SUSSEX ORNITHOLOGICAL SOCIETY

P/153/21 (RES) Approval of reserved matters (appearance, layout, landscaping and scale) following outline planning permission P/140/16/OUT for the erection of 375no. dwellings, together with public open space, play space, drainage, parking and associated infrastructure, landscape, ancillary and site preparation works, with access off Pagham Road (alternative to P/167/21/RES). This site may affect a Public Right of Way.

Land south of Summer Lane and West of Pagham Road, Pagham

The SOS **objects** to this planning application for three reasons:

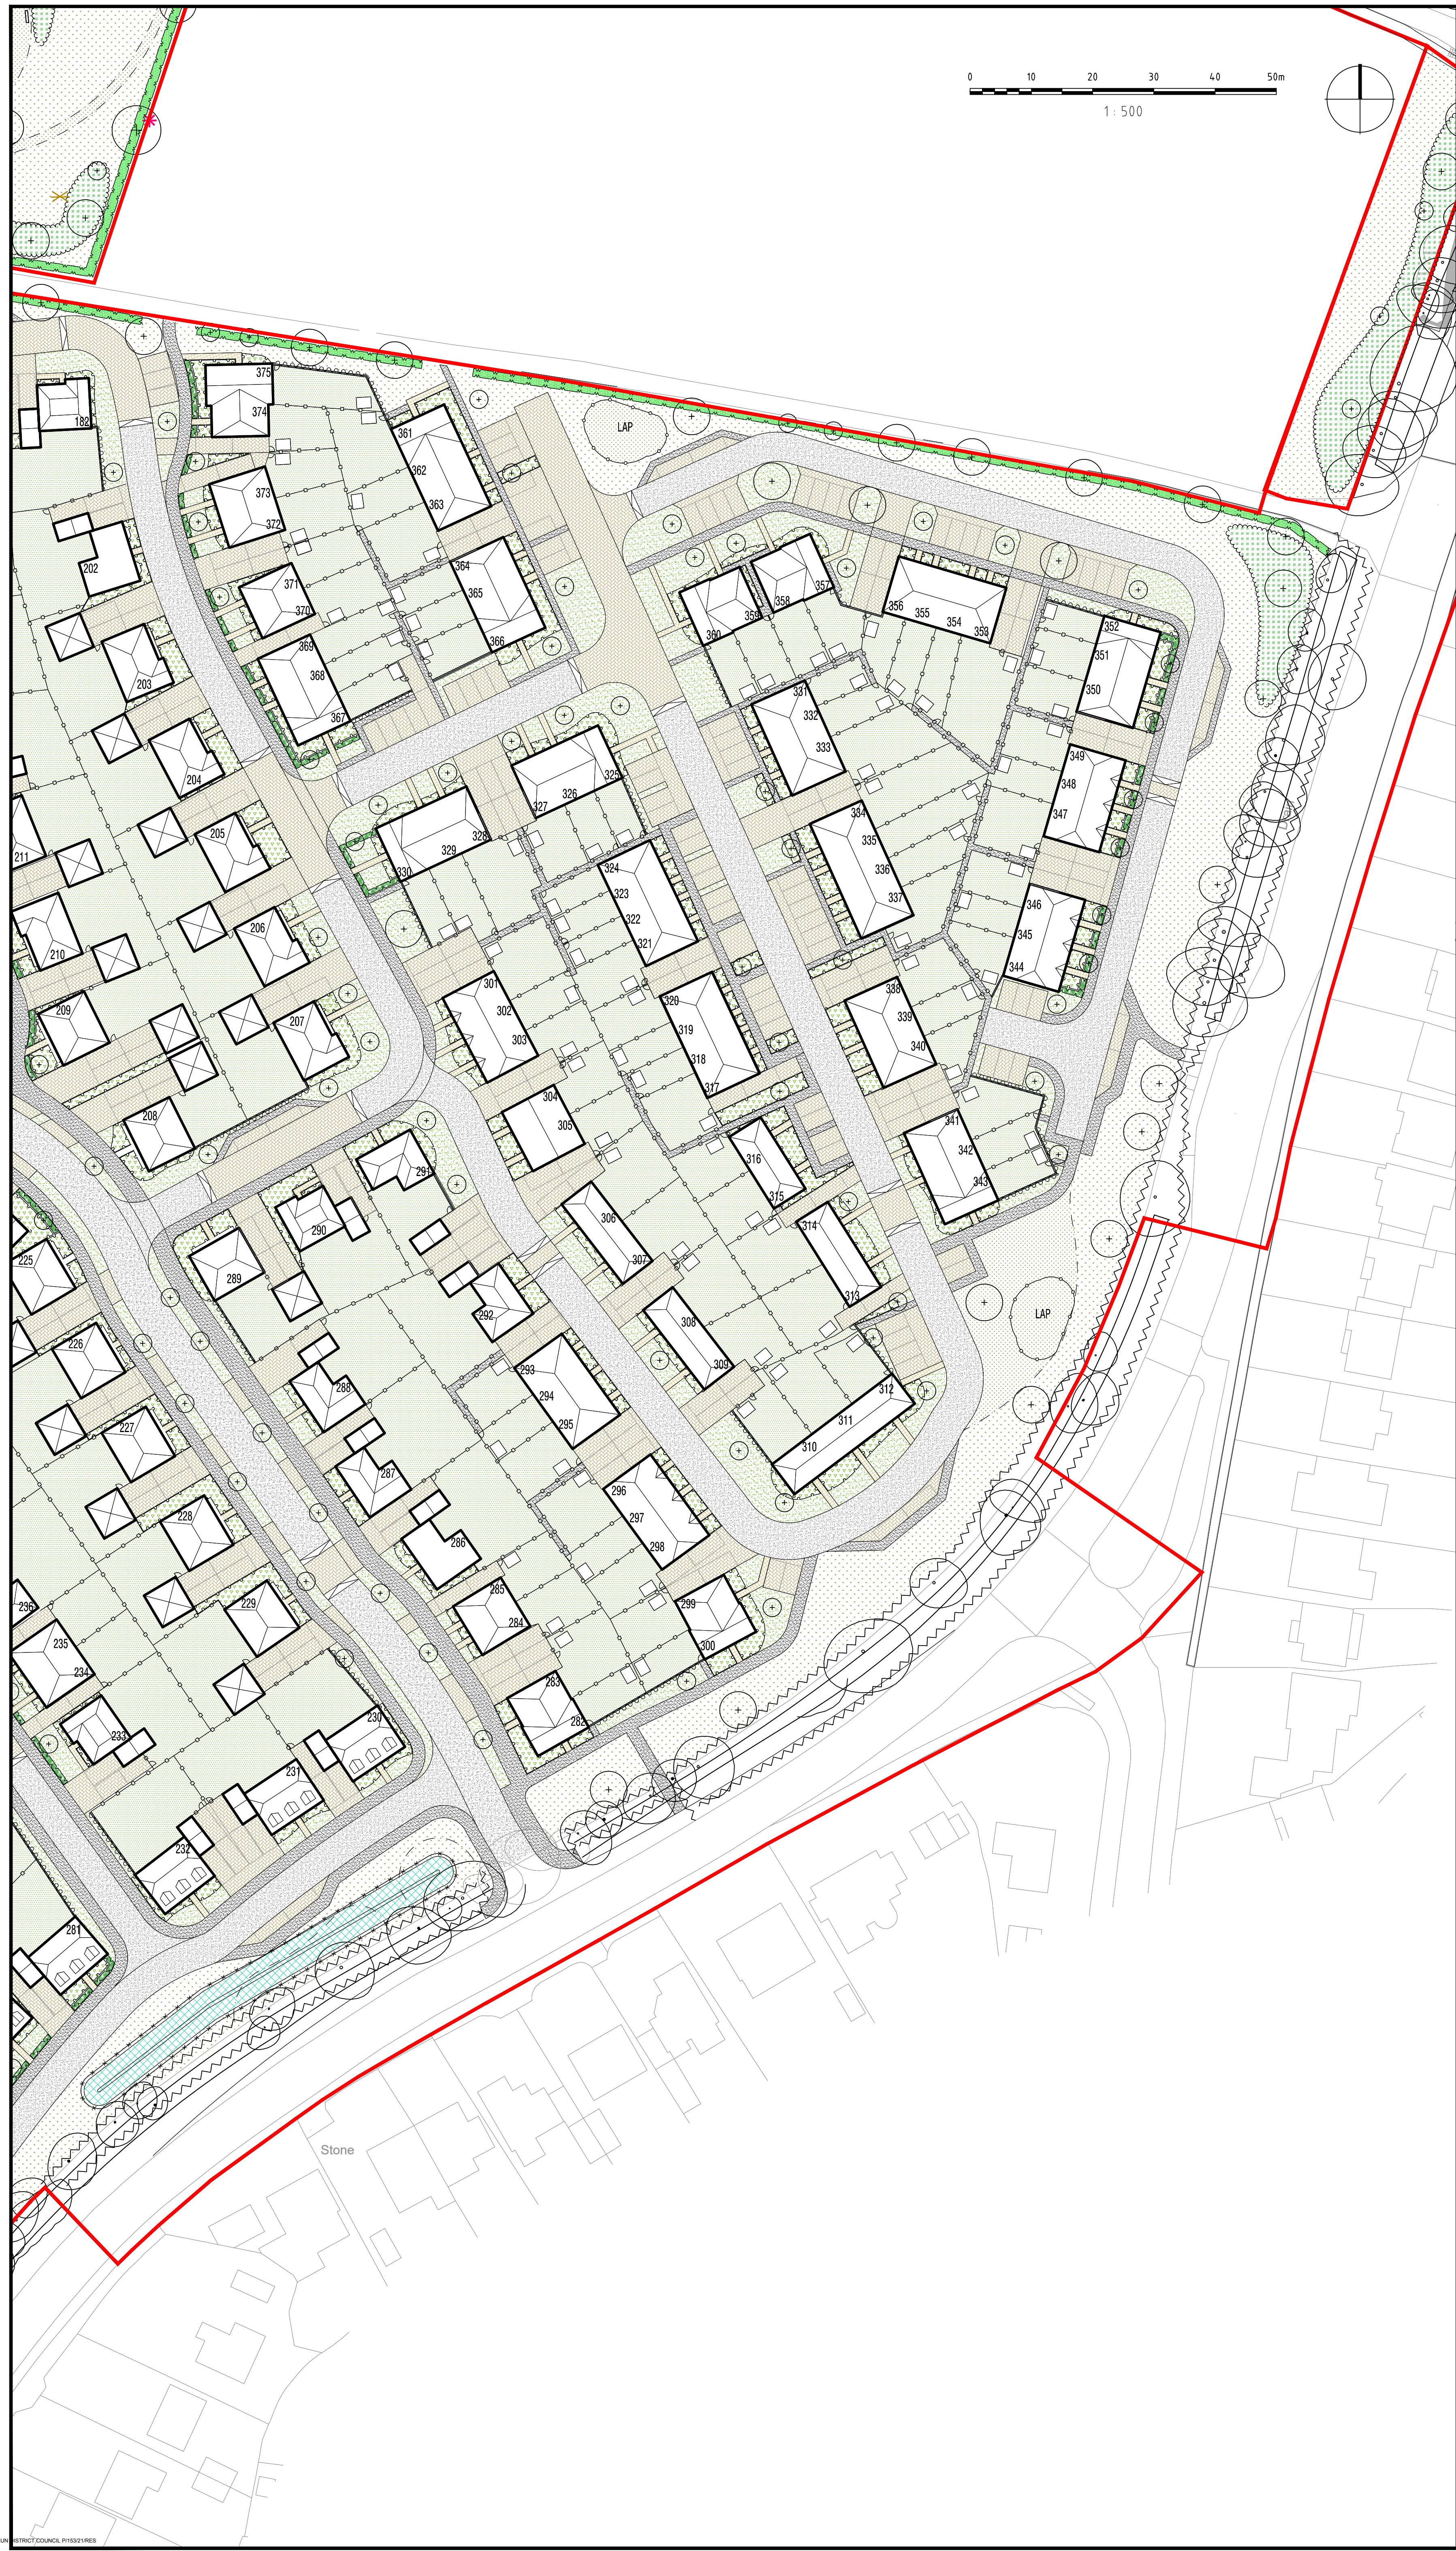
1. The SOS **OBJECTS** to P/153/21/RES because there is very little screening along the western and southern boundaries of the site both of which include footpaths. Birds using the fields to the south and west for foraging would therefore be likely to be disturbed by humans using the footpath along the western boundary, who would clearly be visible to birds in the field as no screening is being proposed.
2. The Officer's Report on P/140/16/OUT sent to the Planning Committee in 2018, stated (page 39)

The landscape proposals along these boundaries clearly fail to deliver the features highlighted in yellow.

3. The proposal in P/153/21/RES to install a LAP at the southern end of the SUDS along the western boundary would potentially cause greater disturbance to birds foraging in the fields to the west, than the proposals in P/167/21/RES. But neither proposal is satisfactory from a birding point of view.

4. We also object because we believe that dogs could freely access the land beyond the western boundary. This is because the proposed narrow strip of "wetland" planting within the SUDs area along the western boundary shown on Landscape Sheets 3 and 5 would only deter dogs crossing the western boundary when the SUDs is flooded to some depth, which presumably will only be on a very limited number of days each year. Therefore, it appears that dogs would be able to run onto these fields across the dry SUDS depression most of the time. There is also a bridge crossing the SUDS which gives direct access into this field.

Since this SUDS is not part of any waterway we question how viable it would be for any wetland planting in it to survive, especially over the summer.
